BUILDING CODE OF AUSTRALIA CAPABILITY STATEMENT - Rev B
Property/Project: Sydney Opera House – White Box (TIDE) – Bennelong Point, Sydney

The purpose of this submission is to advise that we have undertaken a preliminary assessment of the architectural drawings noted in Table 1 below, against the provisions of the Building Code of Australia 2019 (“BCA”) as per the requirements under Clause 145 of the Environmental Planning & Assessment Regulation 2000 (“EP&A Regs”). The project is known as the Tours Immersive Digital Experience (TIDE) within a White Box room. A site inspection was conducted by this office on the 20 August 2019.

Location	Drawing No	Sheet	Rev
SF GF	49-FB-SC029	DA120	A

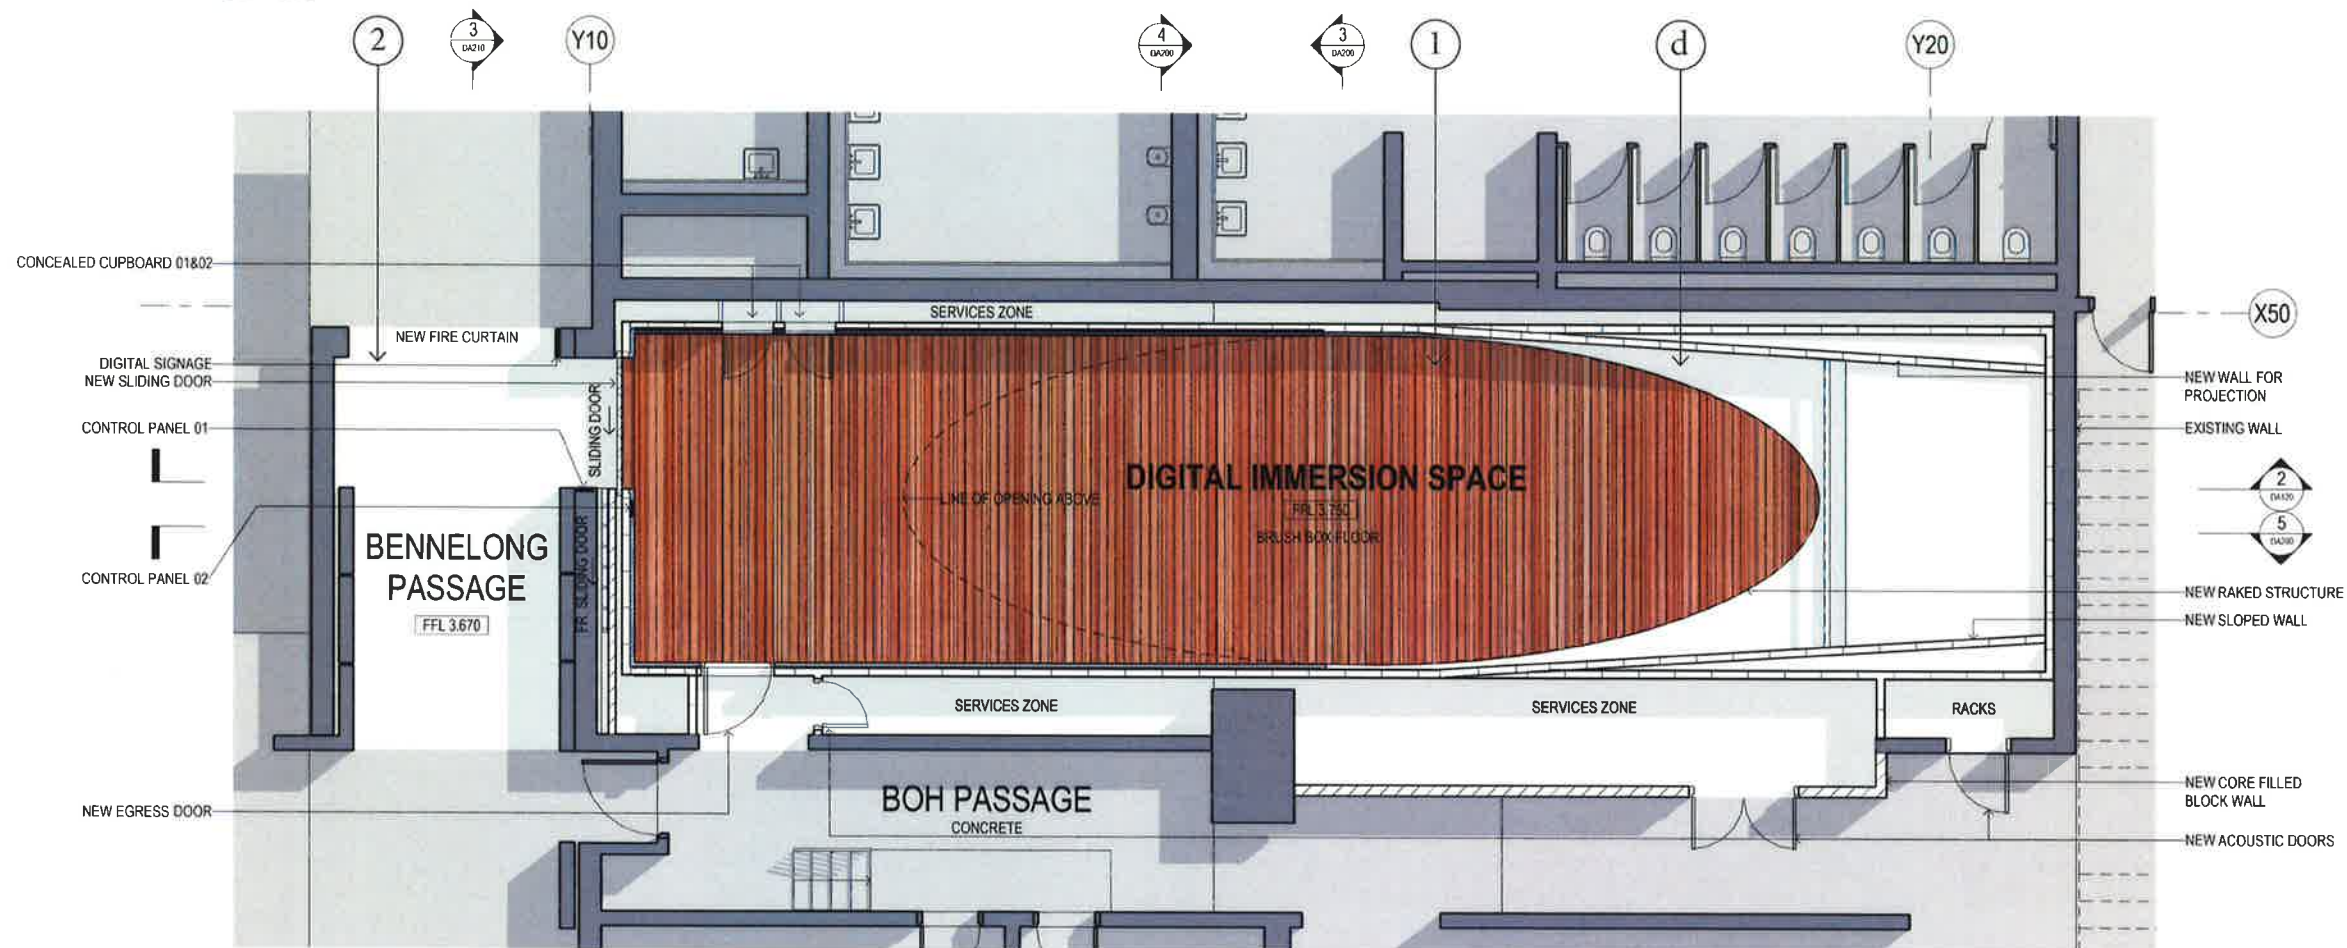
The new sliding fire door and frame are required to achieve an FRL of -/120/30. Fire test reports for the specific product proposed will be required to be submitted prior to the issuance of the Crown Building Works Certificate.

Whilst travels distances are altered slightly, the proposal has low impact on the current egress situation. Diagram 1 below illustrates excessive travel distances in the following areas as illustrated in Table 3 below, worst case scenarios illustrated only:

Location	DTS Travel Distance Requirement	Actual	Design Team Nominated Resolution
Western Foyer (as illustrated in blue in Figure 2.)	20/40/60	7/20/61	Under review. Option to delete the fire curtain currently being explored, which will solve this issue.
Oculus - Eastern most point (as illustrated in red in Figure 2.)	20/40/60	21/35/47	The Fire Safety Engineer has confirmed the feasibility of a Performance Solution which will be justified within the pending FER However, this scenario is only applicable if the southern staff access swing door is deleted. Currently under

The Fire Safety Engineer will need to confirm that the required 1 m path of travel exit width from the White Room does not obstruct any minimum existing allowance width, resulting from aggregate egress calculations that exist in the current Fire Engineered Reports. The only concern is evacuating occupants from the Western Foyers, heading south into the Under the Steps.

NSW Table D1.13 nominates a population of 55 persons based on an area of 67 m, the user has noted that up to 90 persons may occupy in function mode. Whilst Clause D1.13(c) would allow the nomination of 90 persons, further discussion with the Fire Safety Engineer and Mechanical Engineer are required in relation to egress widths and supply air respectively.

- No required panic/push bar to the sliding or hinged door from the White Box. Ref: BCA Clause NSW D2.21(d), Performance Requirement DP2.
- The use of a non-permitted sliding door in the path of travel to an exit. Ref: BCA Clause NSW D2.19(b)(v)(B), NSW D2.101, Performance Requirement DP2.

Location	Drawing No	Sheet	Rev
SF GF	49-FB-SC029	DA200	A A1

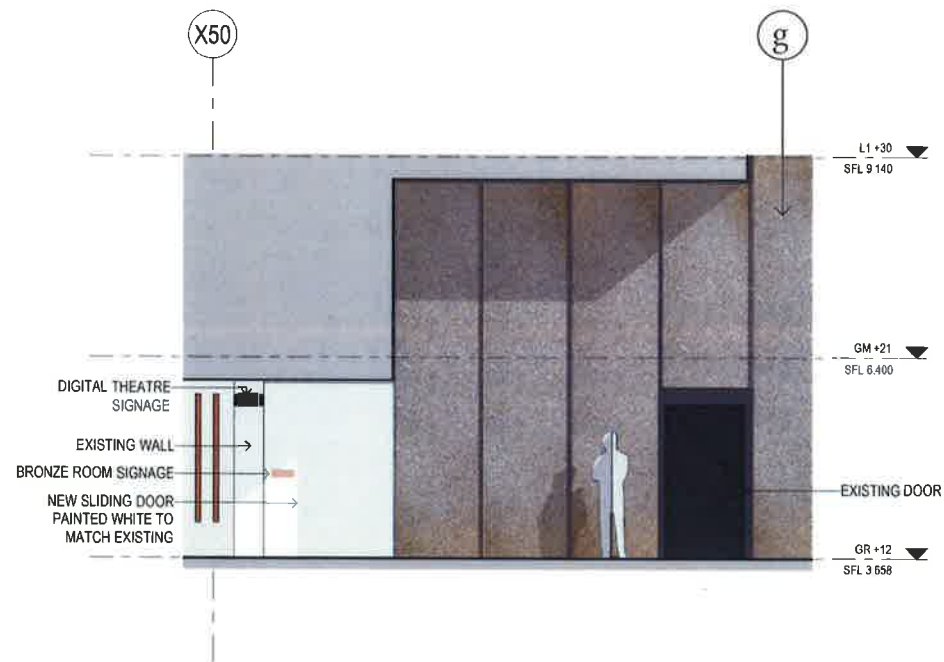
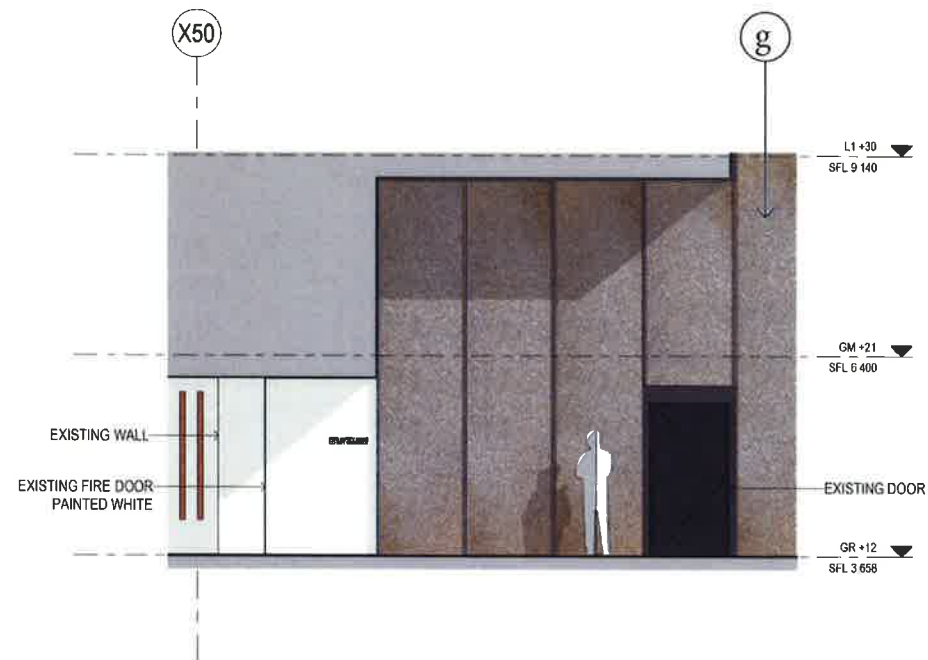
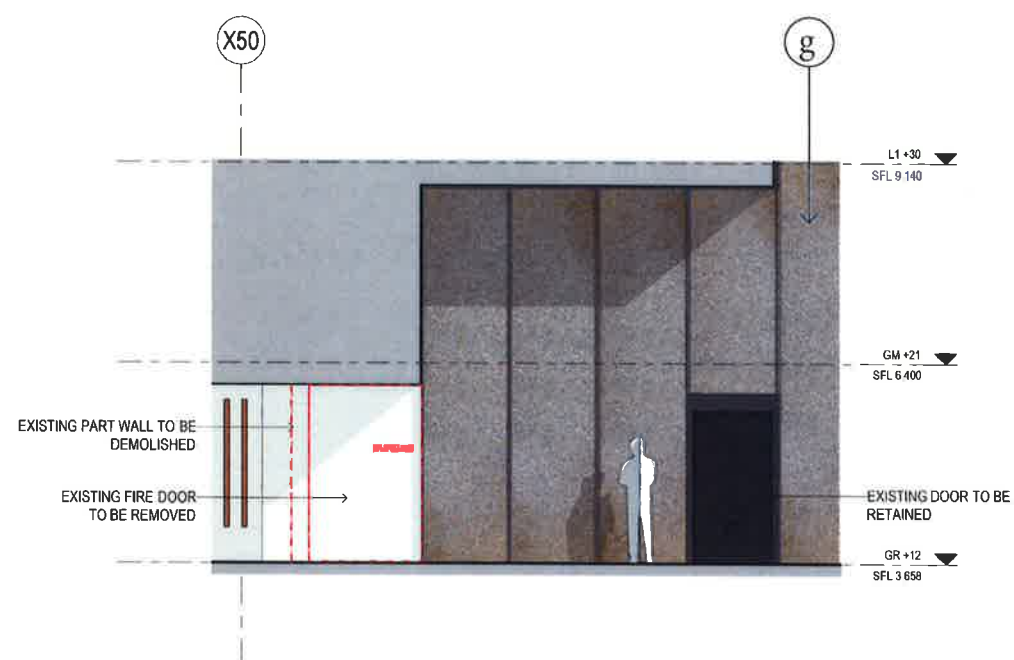
The relevant existing Arup Fire Compartmentation plan (Fire Compartments and Fire Door – Level GR South West 2018 Audit dated 12-11-2018, see Figure 1 below) illustrates a fire compartmentation line/wall to the east perimeter of the White Box. The proposed changes to this wall (provision of a new opening to house a sliding door exit) will not see a decrease in the required fire rating of 120/120/120. The southern and eastern lines/walls are noted in the existing fire compartmentation plans as containing an FRL of 60/60/60. This 60 minute fire rating is not required to be maintained as the proposed White Box is neither a storage room, stage, back stage area or an auditorium. The Fire Compartmentation plans can be updated following issuance of the Crown Completion Certificate for this project.
